EPC STORMWATER REVIEW COMMENTS ARE
SHOWN IN ORANGE BOXES WITH BLACK TEXT

2021 Financial Assurance Estimate Form (with pre-plat construction)

PROJECT INFORMATION			
Falcon Marketplace, Lot 8 - Panda Express	7/23/2021		PPR-21-037
Project Name	Date	PCD File No.

PROPOSED CUT & FILL

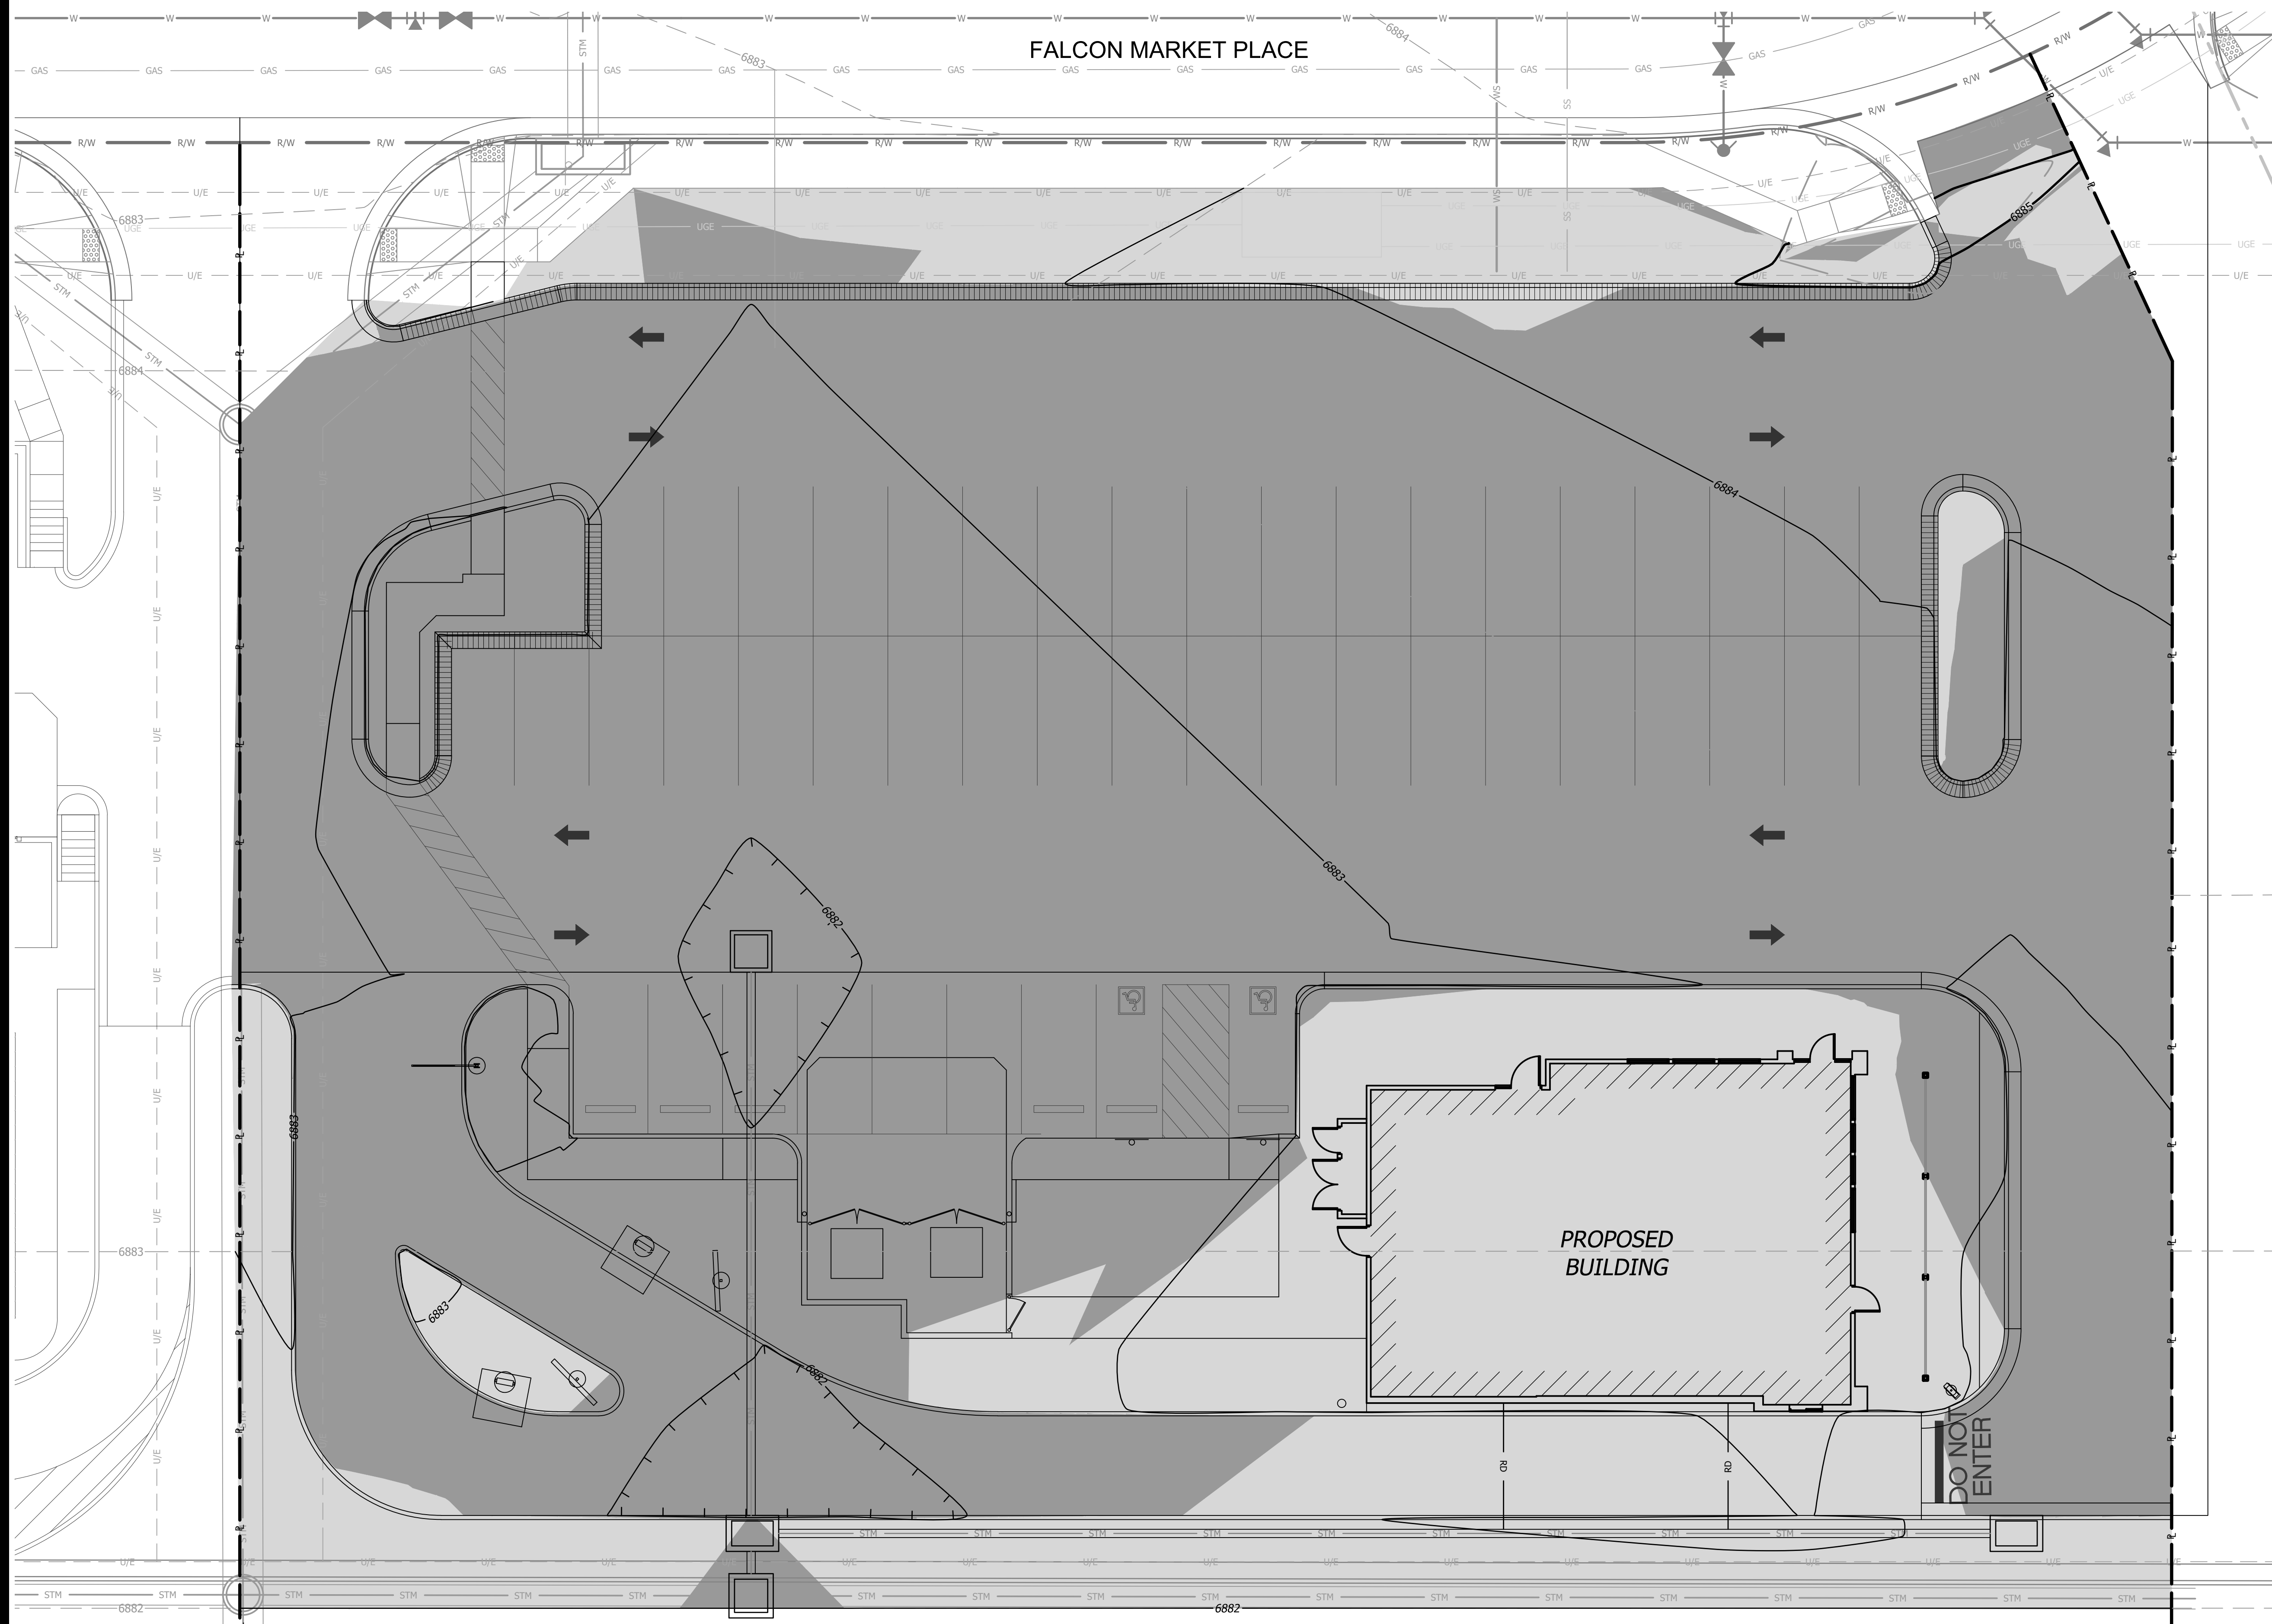
Please use the higher value
of cut and fill volumes, not
the net volume.
